Date: 27 March 2020

Application Ref.: F/5/20/PL

Proposal: Reconfiguration of Ford Market, including revised market access, hardstanding for replacement vehicular parking and associated infrastructure, landscape, ancillary and site preparation works.

Location: Ford Airfield Market Ford BN18 0FL

Drawing Title
PROPOSED SITE PLAN

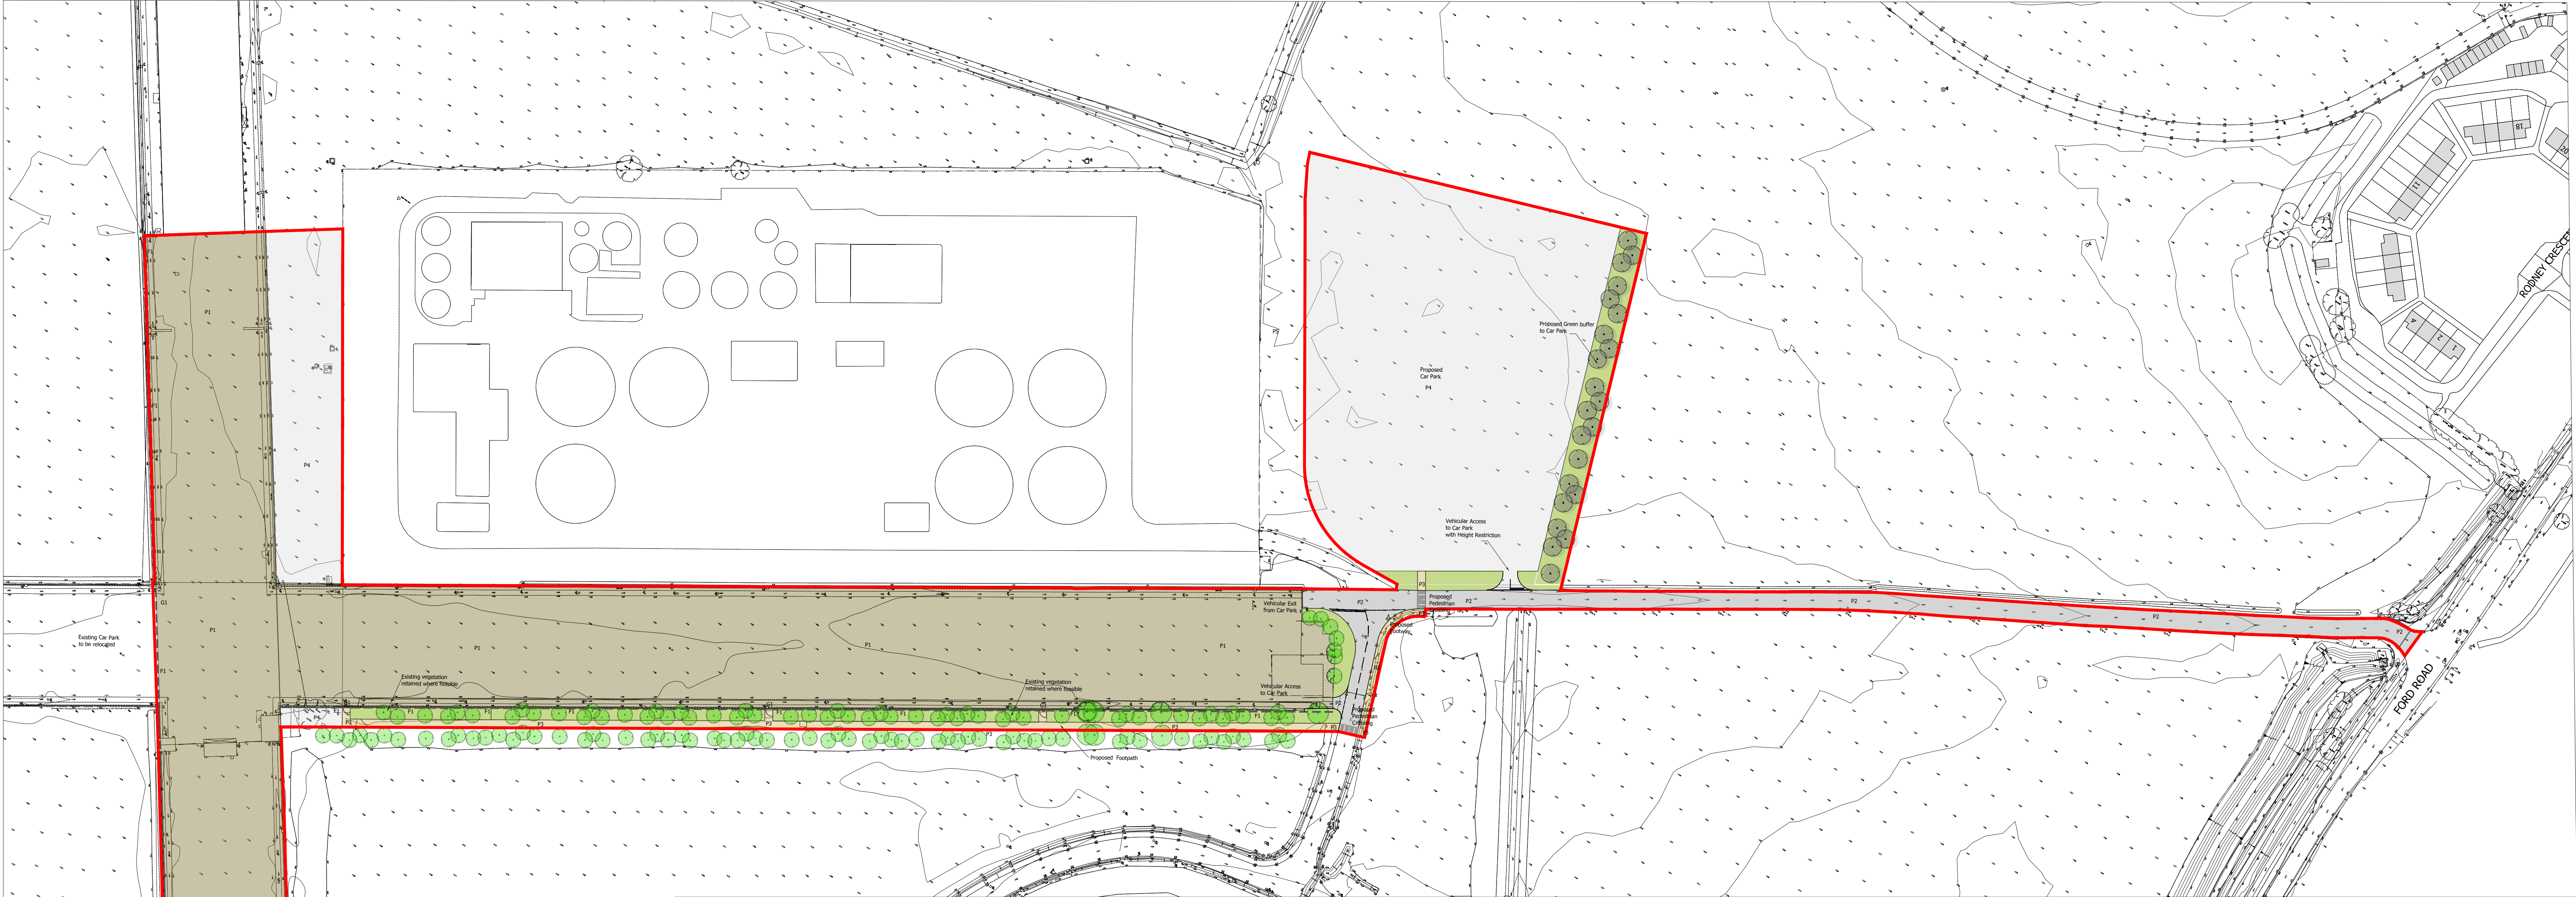
Whilst the application indicates that it is not proposing to intensify the overall use of the market, it proposes one single point of access to the east off Ford Road and hence that access will see an increase in intensity, diverting all traffic visiting the market onto Ford Road and the existing service road ('Hunterford'). This will naturally have the effect of significantly increasing vehicular traffic at the junction of 'Hunterford' with Ford Road.

We also have serious concerns over the revised layout, and in particular the proposal for the new overflow car park and the new pedestrian crossings. This would create a new access point and two new pedestrian crossings, with all of the associated issues in terms of safety and conflicts between vehicles visiting both Viridor and Grundon's sites and the users of the market. The vehicles visiting the waste management sites are heavy goods vehicles, and therefore, there is a clear and unacceptable conflict between the vehicles visiting the waste management sites and pedestrians crossing the roads from the overflow car park to access the rest of the market. The safe and efficient operation these strategic waste management uses will be compromised as a result and we have therefore no option other than to **object** to this application.
